**Planning Ref 18/00825/HYBRID – Application re-consultation, Heyford Park**

- Design & Access Statement, April 2018 (ref P16-0631\_81D)
- Heyford Park Composite Parameter Plan (Drawing no. P16-0631\_08 dated 17/04/2018)
- Heyford Park – Proposed Bridleways Routes (drawing no. D.0342\_51 SHEET NO: \_1 REV: \_E dated 15/10/2018)

HGV PRINCIPLE PLAN

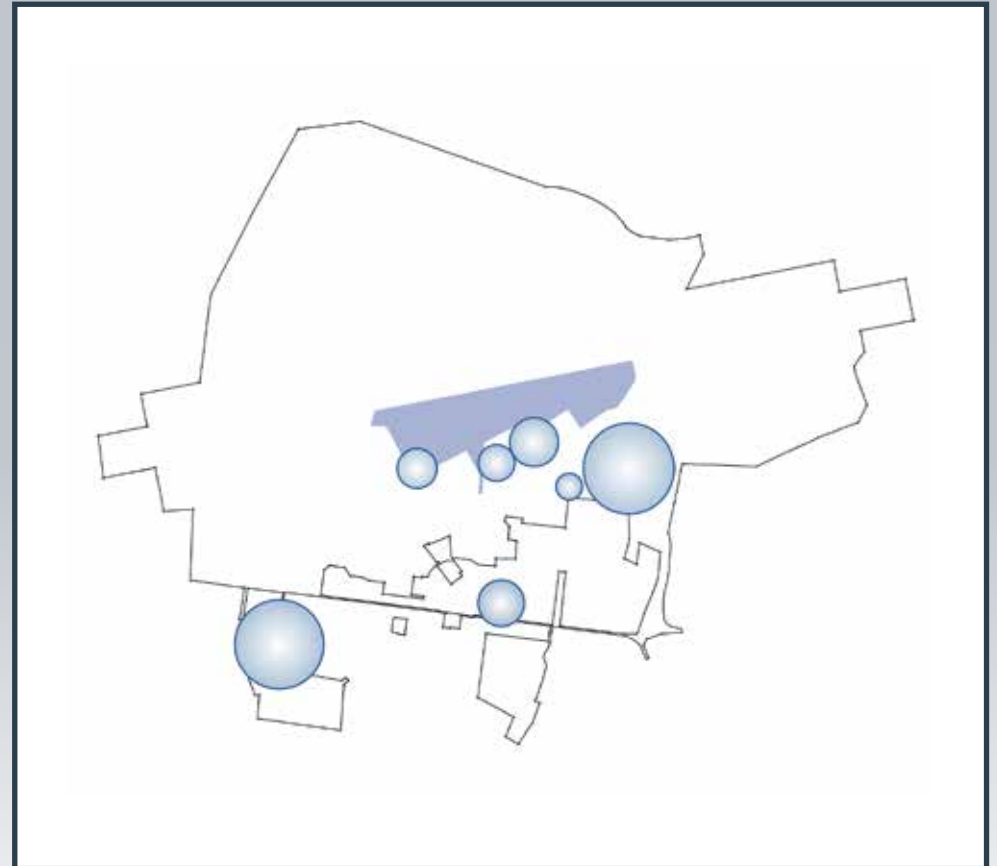
- c. **SAFETY ISSUES / Chilgrove Drive HGV Access:** The proposed route for the new HGV access road runs alongside the new Aves Ditch bridleway for some distance and would cross it approximately 400 metres north of the Camp Road. This is a major concern, as we understand that there may be as many as 5,600 HGV movements per week along this road. We therefore ask that the following be provided to minimise risks to all users of the bridleway (pedestrians and cyclists as well as equestrians):

- i. **Screening:** The proximity of Chilgrove Drive to Aves Ditch within the airfield site is a particular concern as horses can be startled by large vehicles and also by sudden noise such as the application of air brakes. The BHS would therefore ask that the applicant provides details of the screening that will be provided between the bridleway and the HGV access road.

## FOOTPATHS, BRIDLEWAYS AND CYCLEWAYS

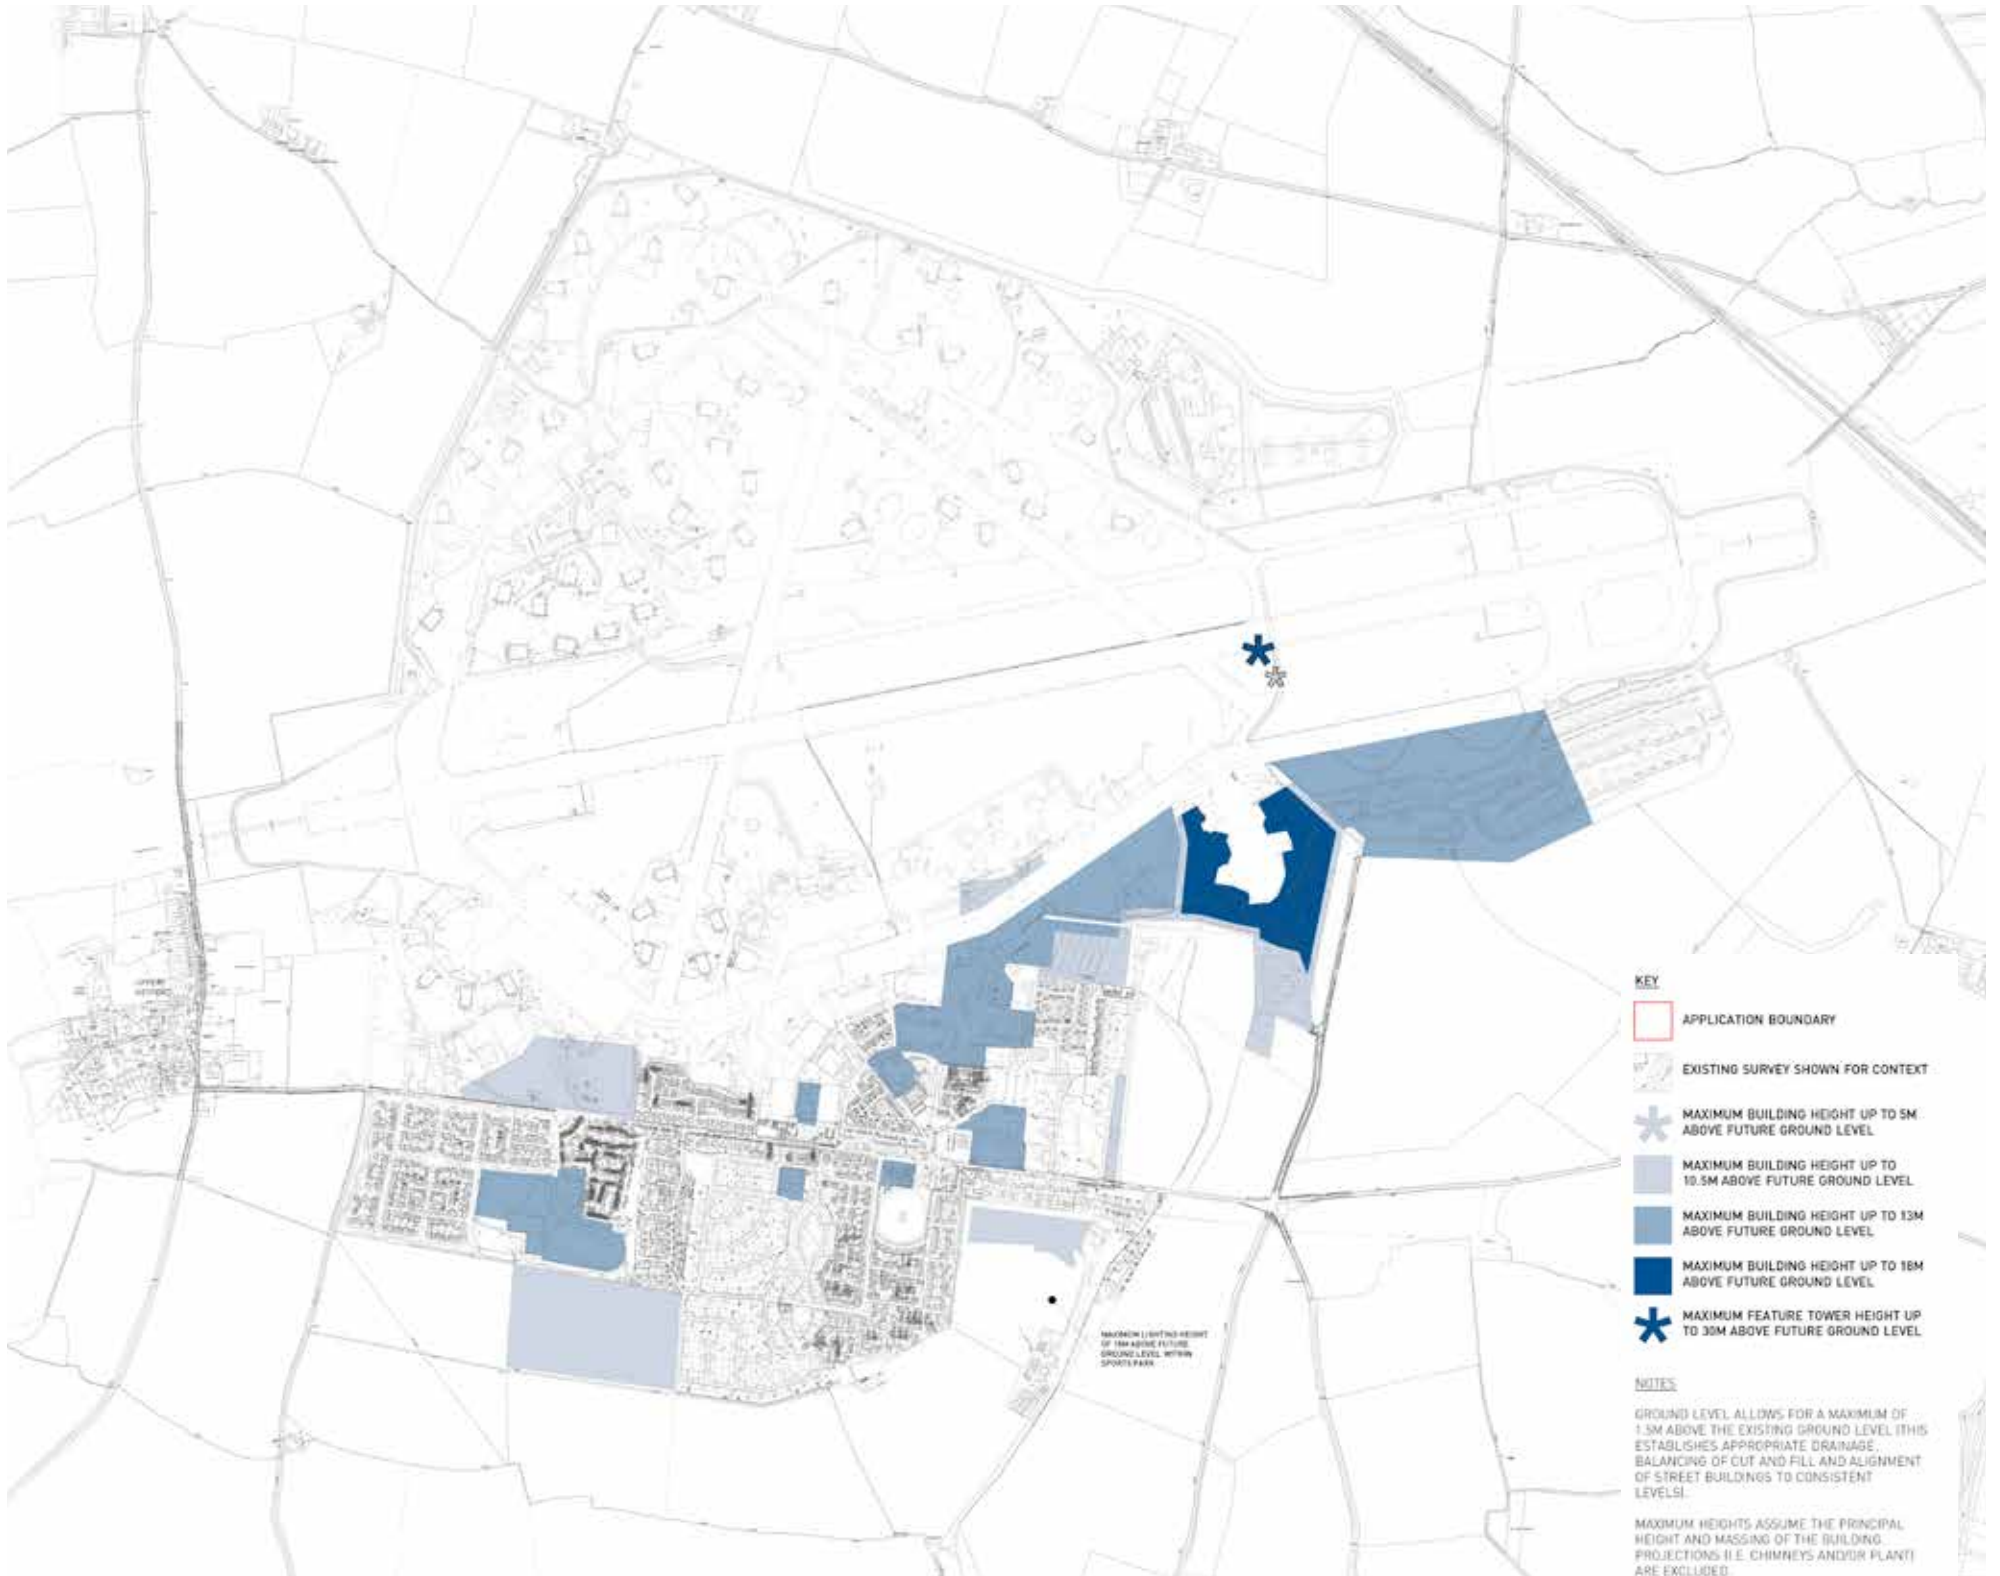
- a. **Surface:** We would expect the Aves Ditch surfacing to be the same as the Coxwell gravel proposed for the Portway. If there is any need for an alternative surface to be considered, it should be noted that **Tarmac / Bitmac is often dangerously slippery for horses and should therefore not be used for surfacing any equestrian route** (see BHS guidance on [Surfaces](#)).

- b. **Width:** BHS advice on [Dimensions for width, area and height](#) is that new bridleways should have a minimum *useable* width of 3 metres at all seasons, irrespective of whether the path is bounded by a hedge or fences, or may be fenced in future. In practice, a useable width is likely to require at least an additional half a metre to each side giving an overall width of 4 metres to avoid such factors as overgrowth reducing the useable width between cuts, or a rider catching a foot in a fence.
